From: William Simcock
Sent: 23 January 2019 12:30
To: DCAdmin
Subject: FW: Further Highways comments 92 New North Road.

From: Jamie Turner
Sent: 23 January 2019 10:07
To: William Simcock <William.Simcock@kirklees.gov.uk>
Subject: RE: 92 New North Road.

From: William Simcock
Sent: 16 January 2019 10:10
To: Jamie Turner <Jamie.Turner@kirklees.gov.uk>
Subject: FW: 92 New North Road.

DRAWING DESCRIPTION
Car Park - Swept Paths
1 of 2

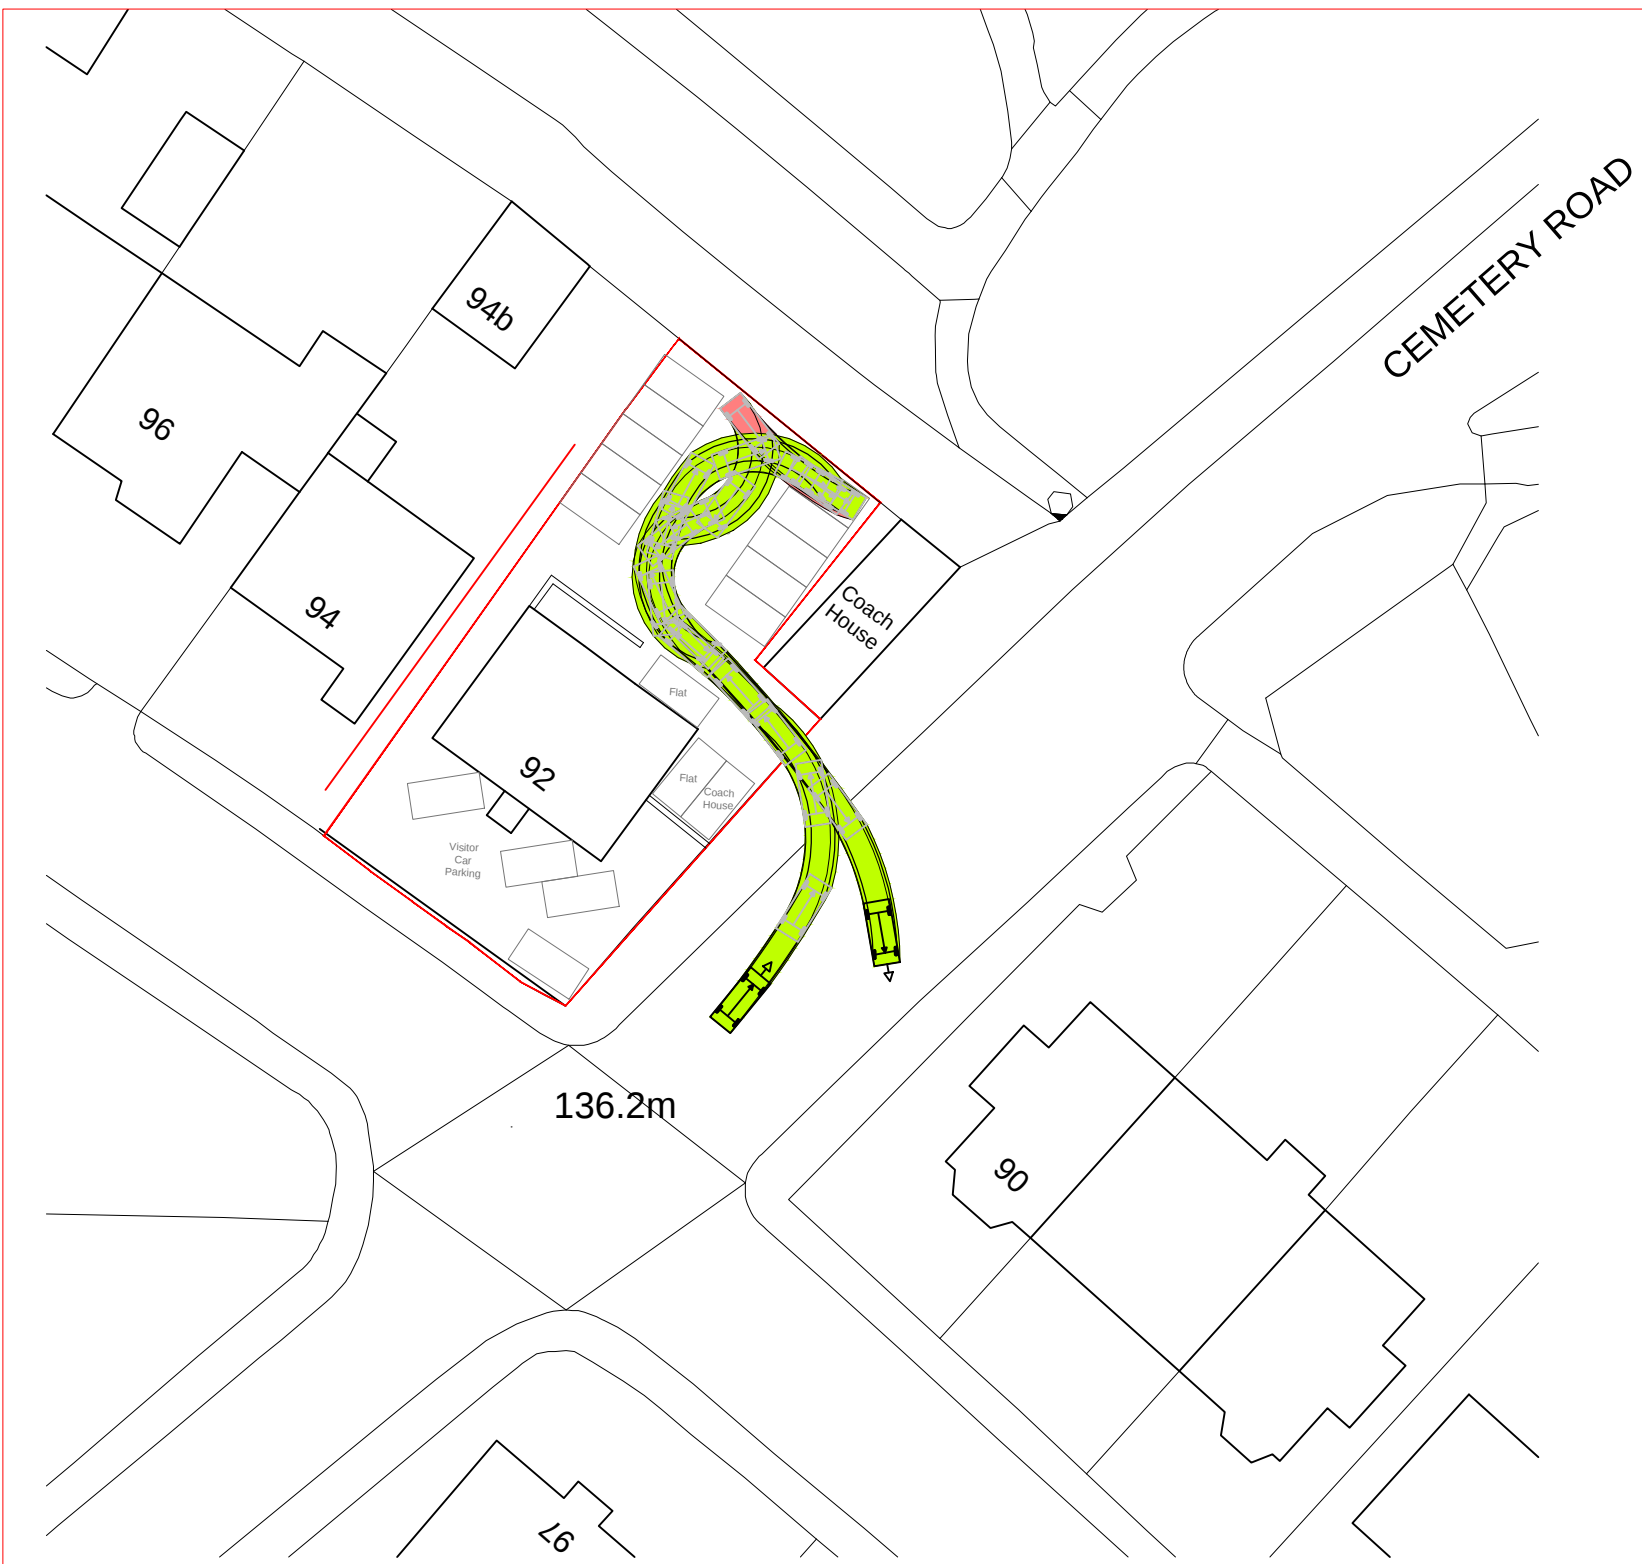
Given the location of the site, I feel the bays to the rear of the site would cover our minimum requirement for off-street parking provision. That said, I believe the front bays are accessible by a regular-sized car without crossing the red line boundary; there is approximately 2.3m of clearance even taking into account the chimney stack.

These are the latest swept paths. One parking space has been deleted. I think the number is more than adequate for a site with good public transport, but I would like your reassurance that the swept paths are okay.

Given the above, the scheme is acceptable from a highways point of view.
